Application Ref:	2025/0552			 Ribble Valley Borough Council www.ribblevalley.gov.uk
Date Inspected:	17.09.25	Site Notice:	17.09.25	
Officer:	Stephen Kilmartin			
DELEGATED ITEM FILE REPORT:				APPROVAL

Development Description:	Listed Building Consent for external works to building to facilitate change of use from farm dwelling to offices for Ribble River Trust.
Site Address/Location:	Horrocksford Old Hall Farm West Bradford Road Clitheroe BB7 4QD

Window Details

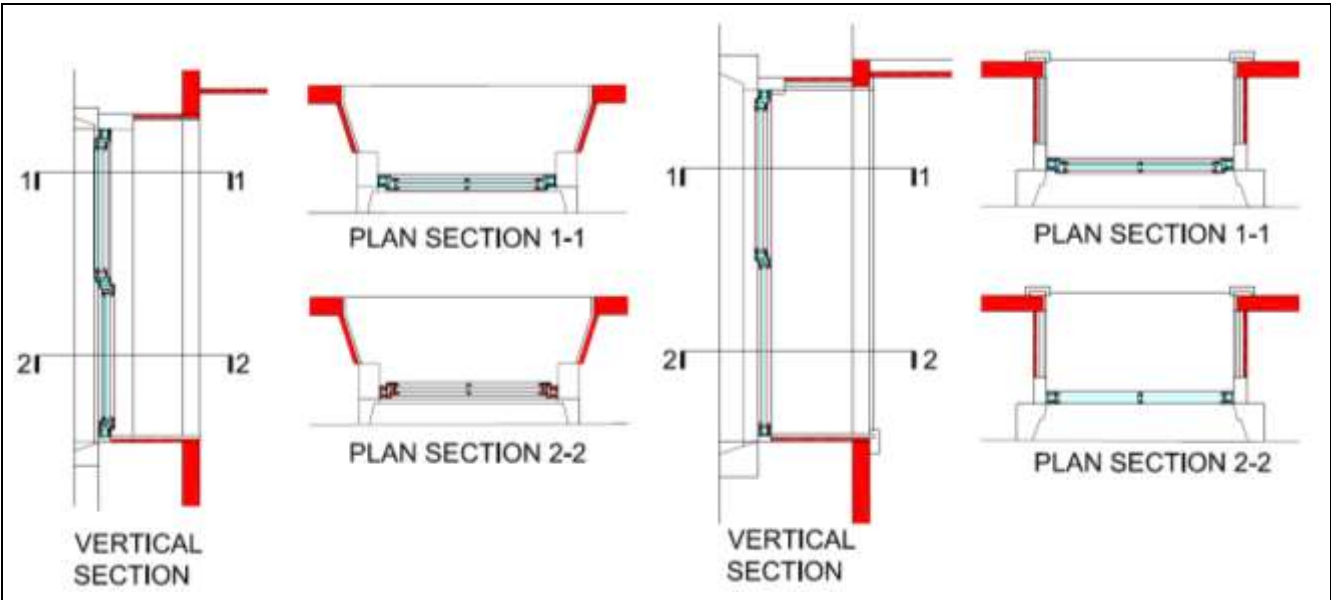
In respect of the proposed 'replacement of existing timber windows with UPVC windows to match existing UPVC windows'. The authority would not normally consider that the removal of the existing timber windows and installation of replacement UPVC Windows to be an appropriate approach. However, given the majority of the windows already installed upon the building are UPVC and given the increased impetus to bring the building into a functional use, the authority considers that the harm resultant the removal and replacement of the existing timber windows would be significantly outweighed by securing and enable a viable use of the building for commercial purposes. The submitted details further propose the replacement of existing 'rooflights' with that of 'pre-finished' metal-clad rooflights. No details have been provided in respect of these matters as such conditions will be imposed requiring the submission of section and profile details of the 'rooflights' to be installed.
